**A38 Derby Junctions**  
**TR010022**

**8.91 Applicant's Responses to Information  
or Submissions Received by Deadline 8**

**Applicant's Responses to Information or Submissions  
Received by Deadline 8**

<b>Regulation Number</b>	Rule 8(1)(k)
<b>Planning Inspectorate Scheme Reference</b>	TR010022
<b>Document Reference</b>	TR010022/APP/8.91
<b>Author</b>	A38 Derby Junctions Project Team, Highways England

I Role

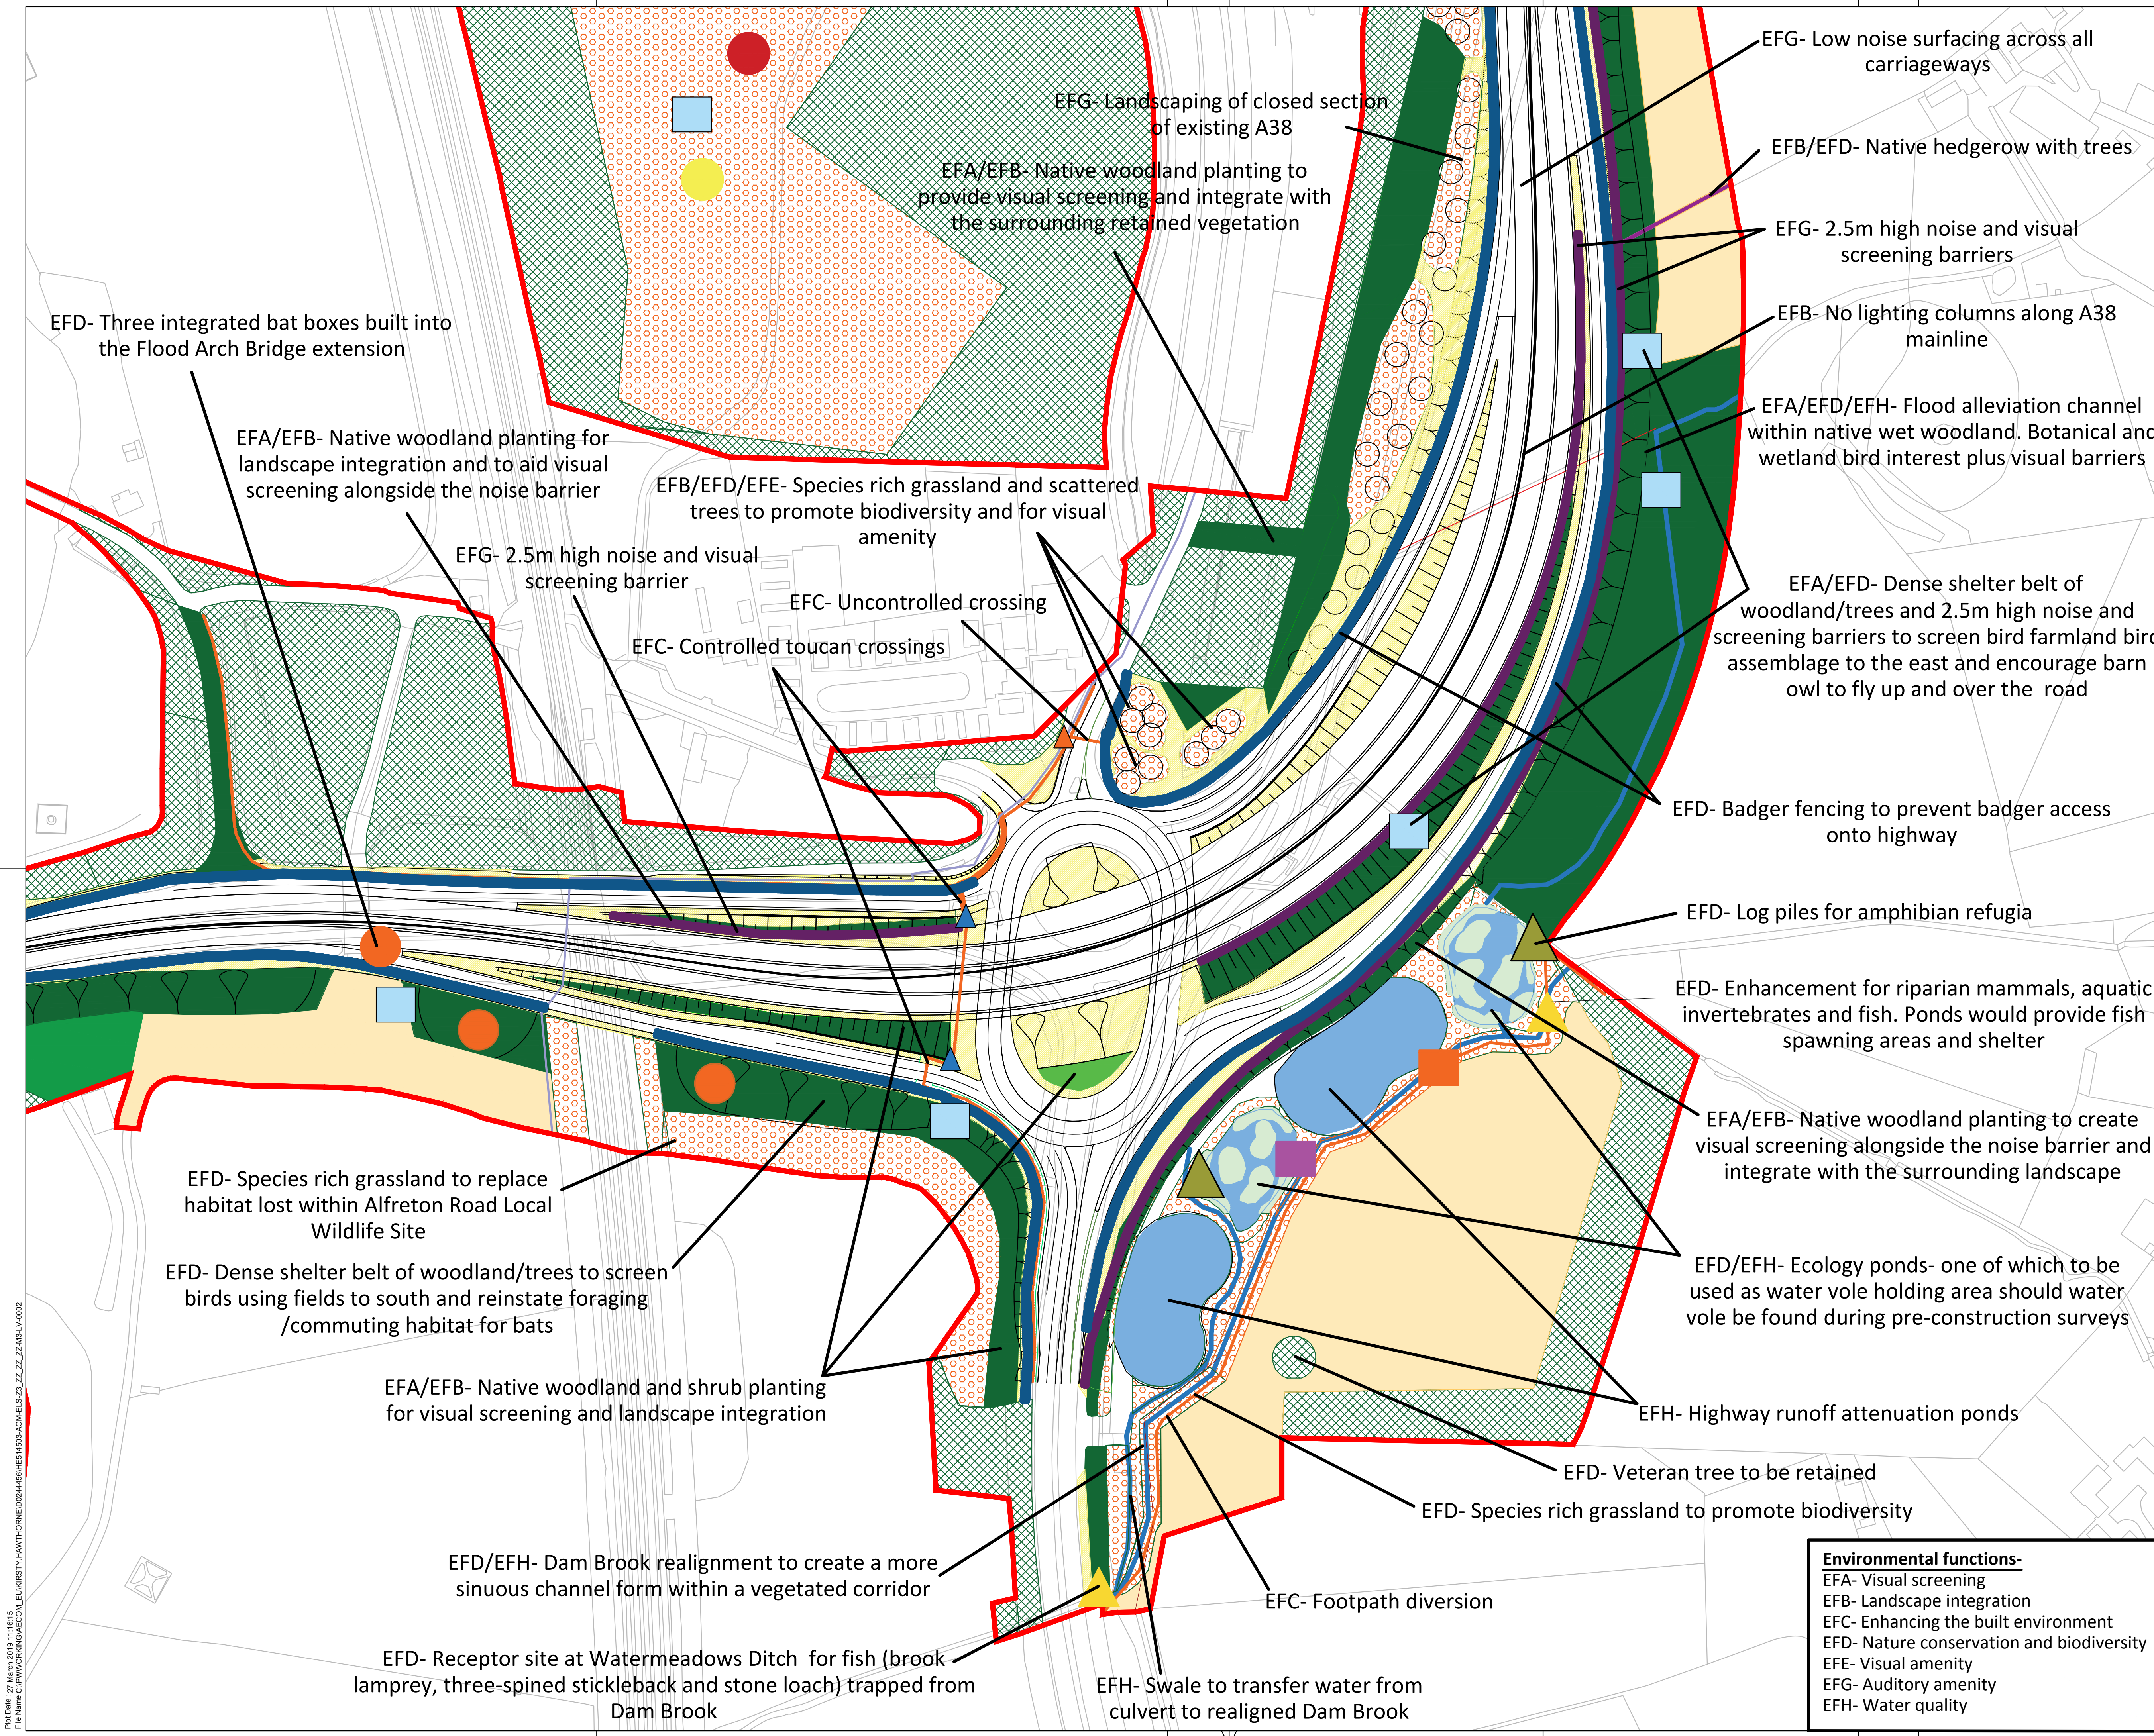
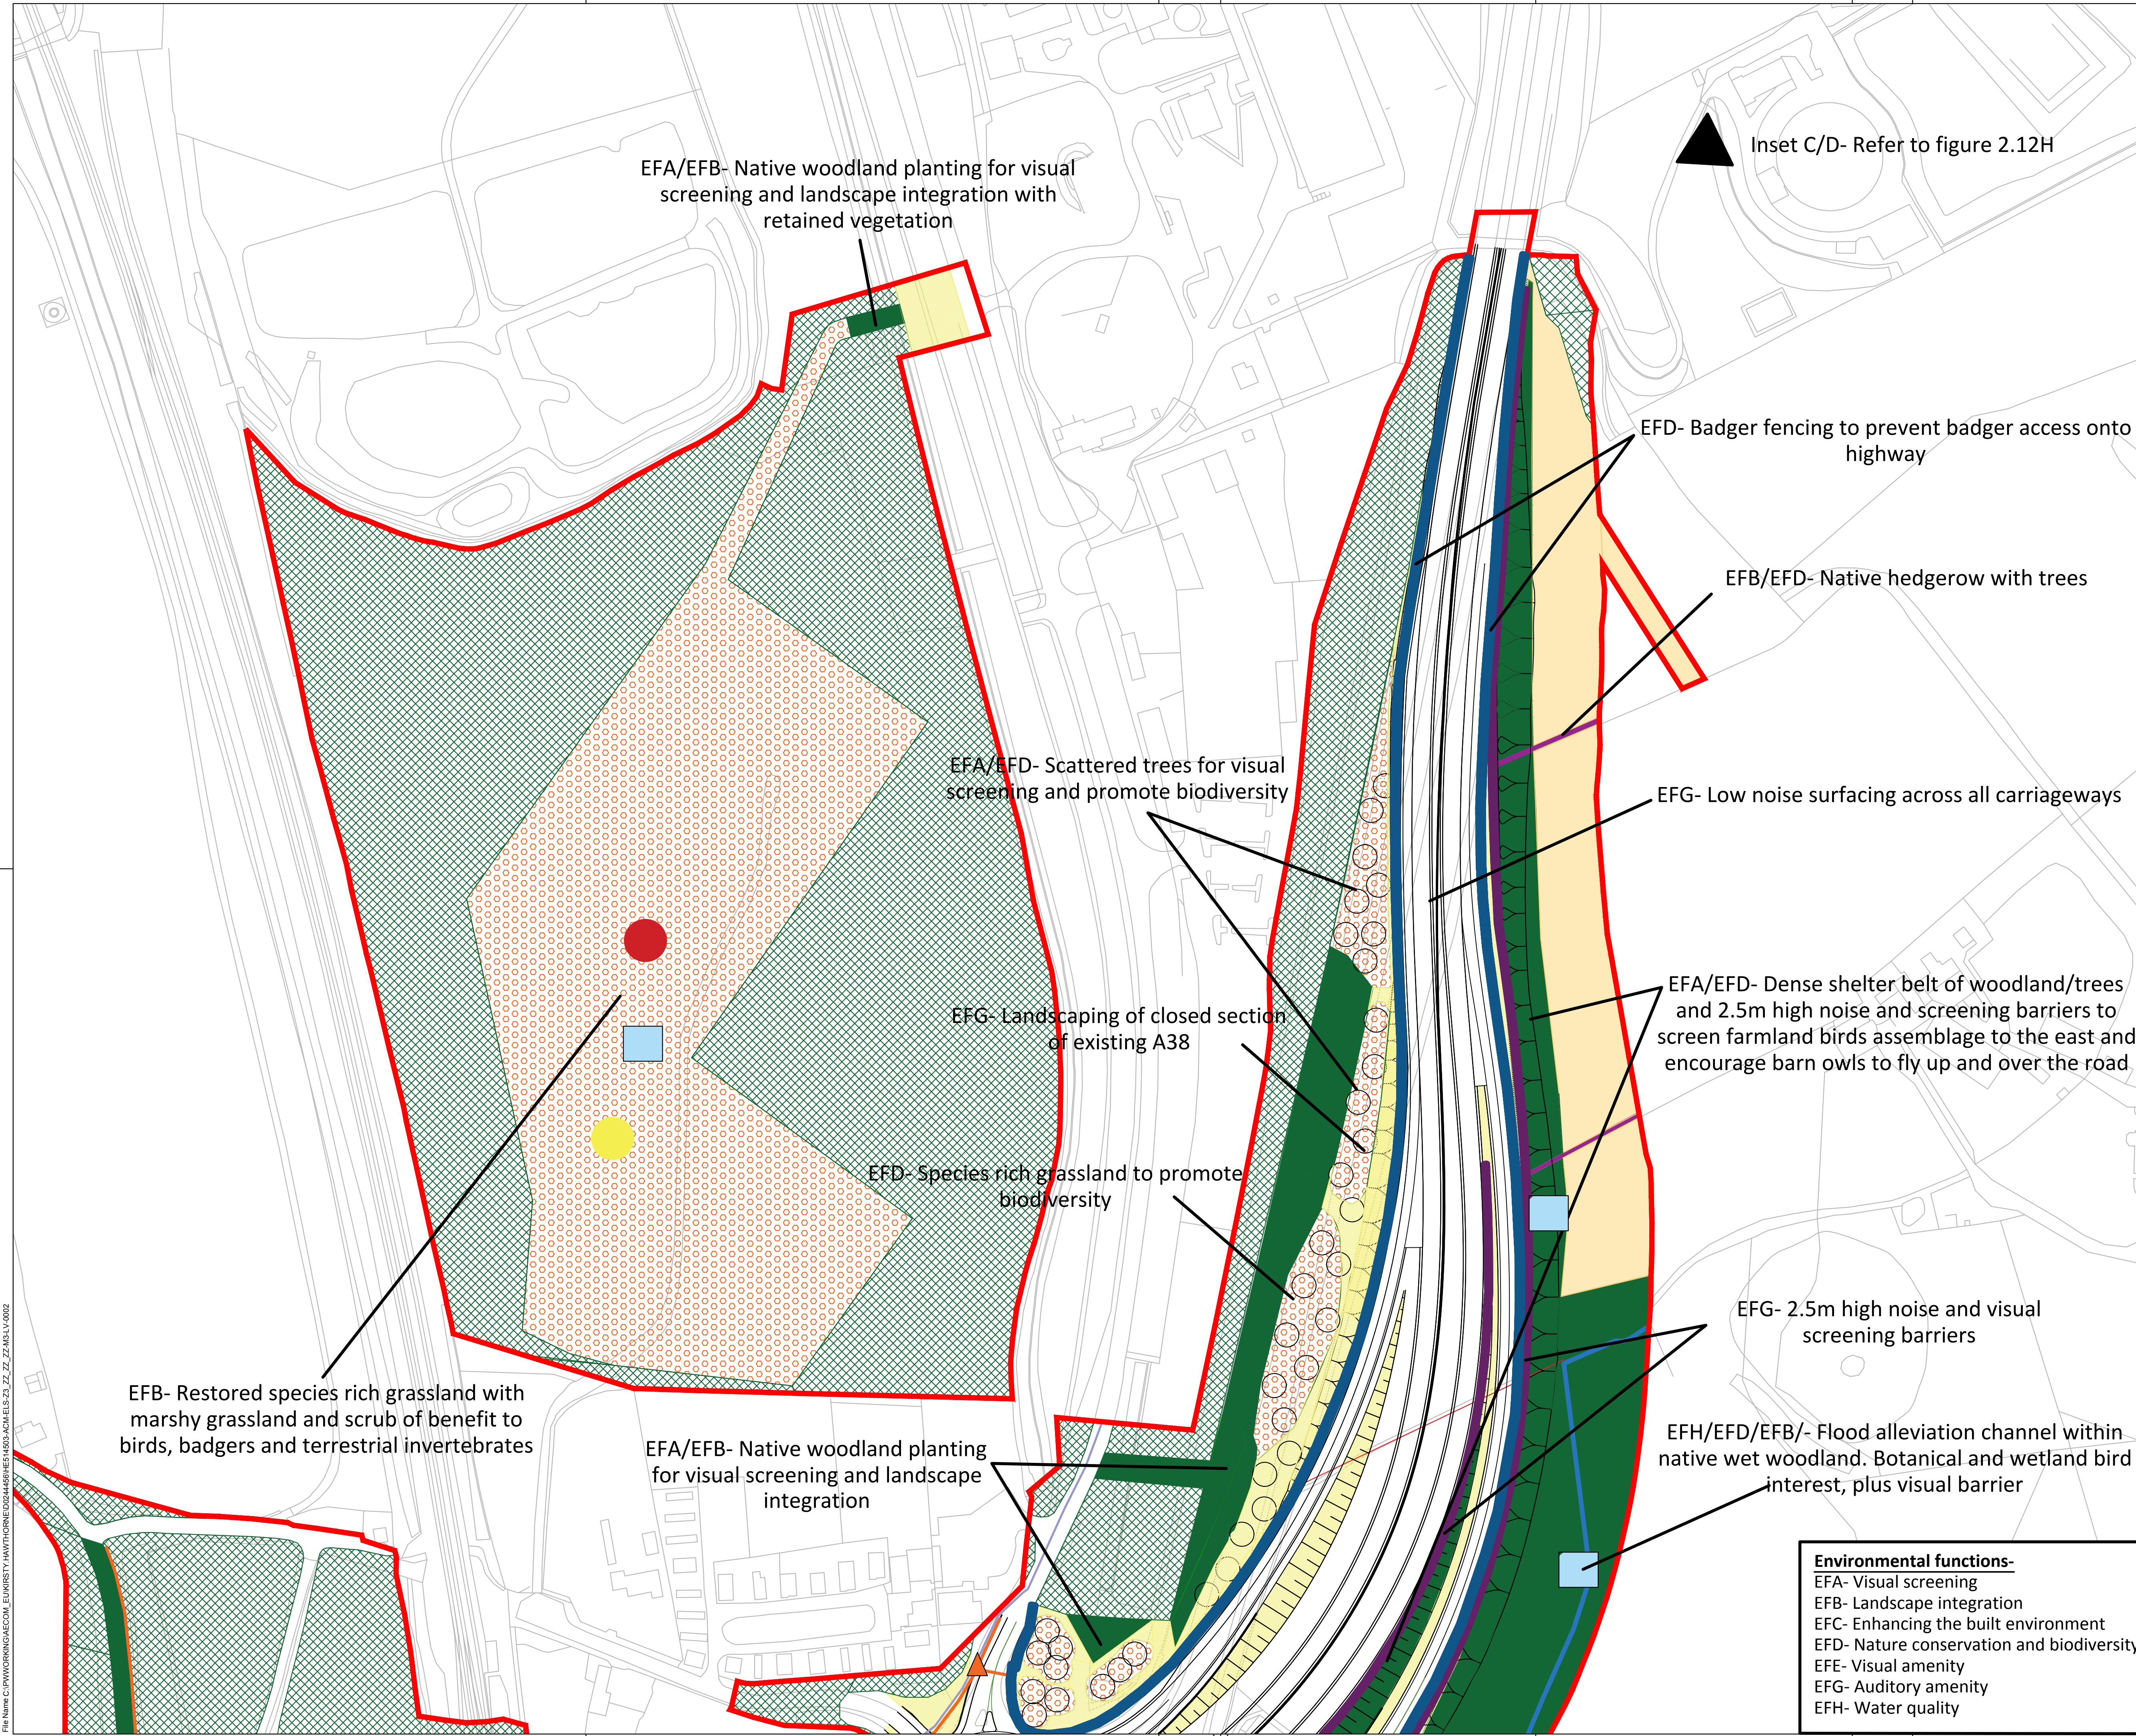
Source	Comment	Applicant's Response
	<p>The Proposed mitigation has not been shown to have equal environmental value, and is unlikely to show any net gain.</p> <p>The mitigation saplings cannot absorb the same amounts of Carbon dioxide as trees and hedging that grow millions of leaves.</p> <p>Semi-mature disease-resistant Elms are to be planted very close to the newly dug diverted utilities corridor. Won't they be disturbed if the any of the diverted utilities have to be inspected for preventative maintenance or for upgrade or repair?</p> <p>If one of the utilities in that corridor needs the repair when one of the trees turned into a totem pole there is successfully used as maternity bat roost, what a dilemma as the penalties per bat disturbed clash against penalties for loss of the service of that utility.</p>	<p>A wide range of ecological mitigation measures have been integrated into the Scheme design – these are illustrated in the Environmental Masterplans (ES Figures 2.12A and 2.12H) [APP-068]. Such mitigation measures have been defined in consultation with key ecology stakeholders, including the local authorities, Natural England, the Environment Agency and Derbyshire Wildlife Trust. Taking into account the defined mitigation strategy, ES Chapter 8: Biodiversity [APP-046] provides details of the Scheme effects during both construction and operation. This chapter reports a moderate adverse significant effect (at the County or Unitary Authority scale) on the A38 Kingsway Roundabout Local Wildlife Site (LWS) due to complete permanent loss of this LWS. However, there is potential for there to be up to a moderate beneficial significant effect (at the County or Unitary Authority scale) on biodiversity in the medium to long term; particularly on standing water (ponds), running water, foraging and commuting bats, otter, terrestrial invertebrates, aquatic invertebrates and fish.</p> <p>For NSIPs such as the Scheme, there is no explicit requirement to demonstrate no net loss or net gain. Nevertheless, the Scheme has sought to maximise opportunities for enhancement in biodiversity associated with defined mitigation measures.</p>

Source	Comment	Applicant's Response
		<p>During the development of the Scheme design, Highways England has sought to minimise the loss of existing trees, and where such losses are unavoidable, mitigation planting is proposed as indicated in the Environmental Masterplan figures (ES Figure 2.12A to 2.12H [APP-068]). Land use changes associated with the Scheme have been taken into account by the climate assessment as reported in ES Chapter 14:Climate [APP-052]. It is acknowledged that newly planted trees will take time before they are able to take up as much carbon dioxide as mature trees. This has been taken into account by the carbon impact assessment.</p> <p>With regard to the trees planted in the vicinity of the utilities corridor along the edge of Markeaton Park (including the proposed disease-resistant elms), these will be planted back from the repositioned utilities such that should any future utilities work be needed, the planted trees will not be affected. The same is true of the three totem poles to be formed with felled trees – these too will be set back from the utilities corridor such that any future utilities works will not disturb them.</p>
